From: David Fuller [REDACTED]
Sent: 20 May 2019 16:29
To: Zac Denton
Cc: Laura Gibbons; architectural@fuller-associates.co.uk; Robert Clark
Subject: Re: Apple Barn Cottage - CM/5/19/HH

Project			
Apple Barn Cottage			
A259			
Climping			
Client			
Alex Stephens			
Drawing Title			
Surface Water Drainage			
© This drawing is copyright. It may not be copied or reproduced without written authority.			
Scale	As shown	At original	A3
Drawing Number	2017/SK4	Revision	-

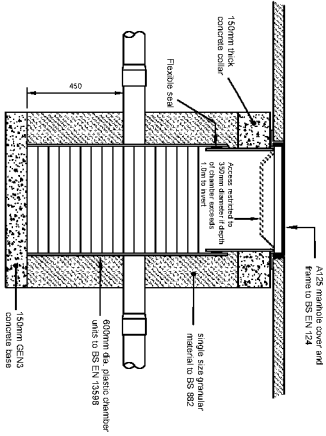
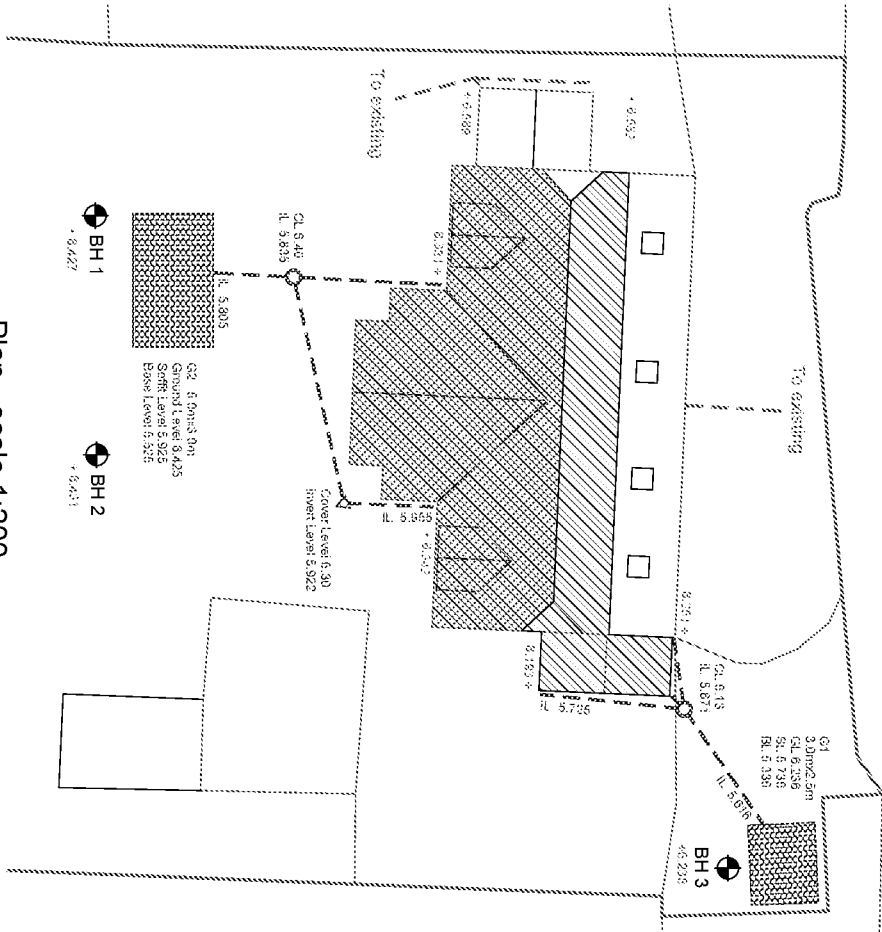
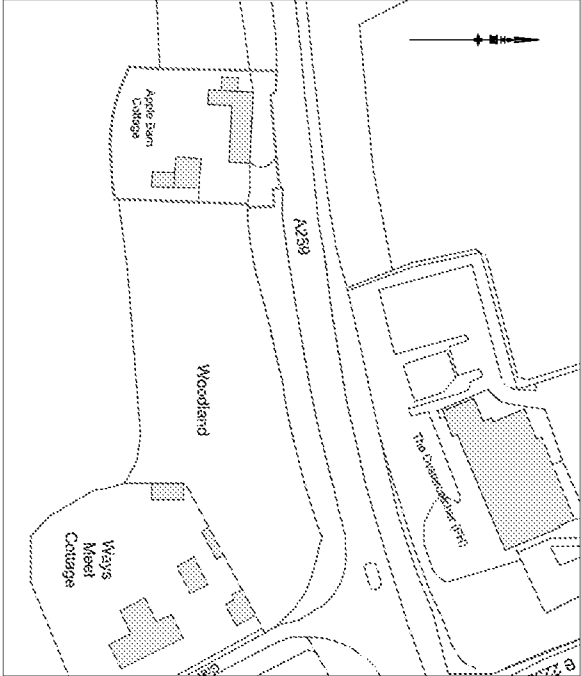
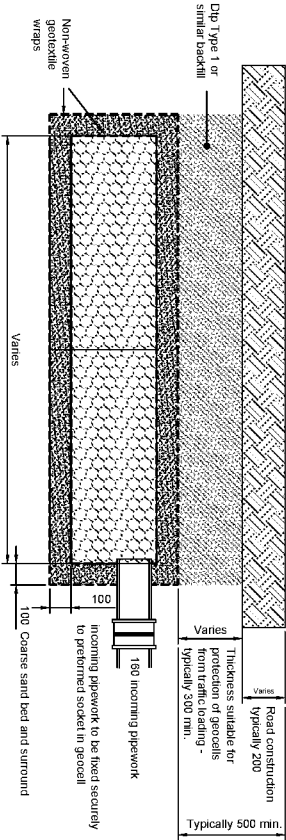
Further information has been provided about the depth of infiltration tests and the rates at each testing location. I would like to see the test result from BH3 used in design of G1 soakaway. And the infiltration rate of BH2 at 929mm depth used in the design of G2 soakaway. These results are those that most accurately reflect the location and depth of the proposed soakaways."

Please can the applicant also submit further details of the infiltration testing. I note that the layout states that an average rate has been used in design. Please can the depths of infiltration testing and results be supplied to ensure that the infiltration rate used in design is appropriate.
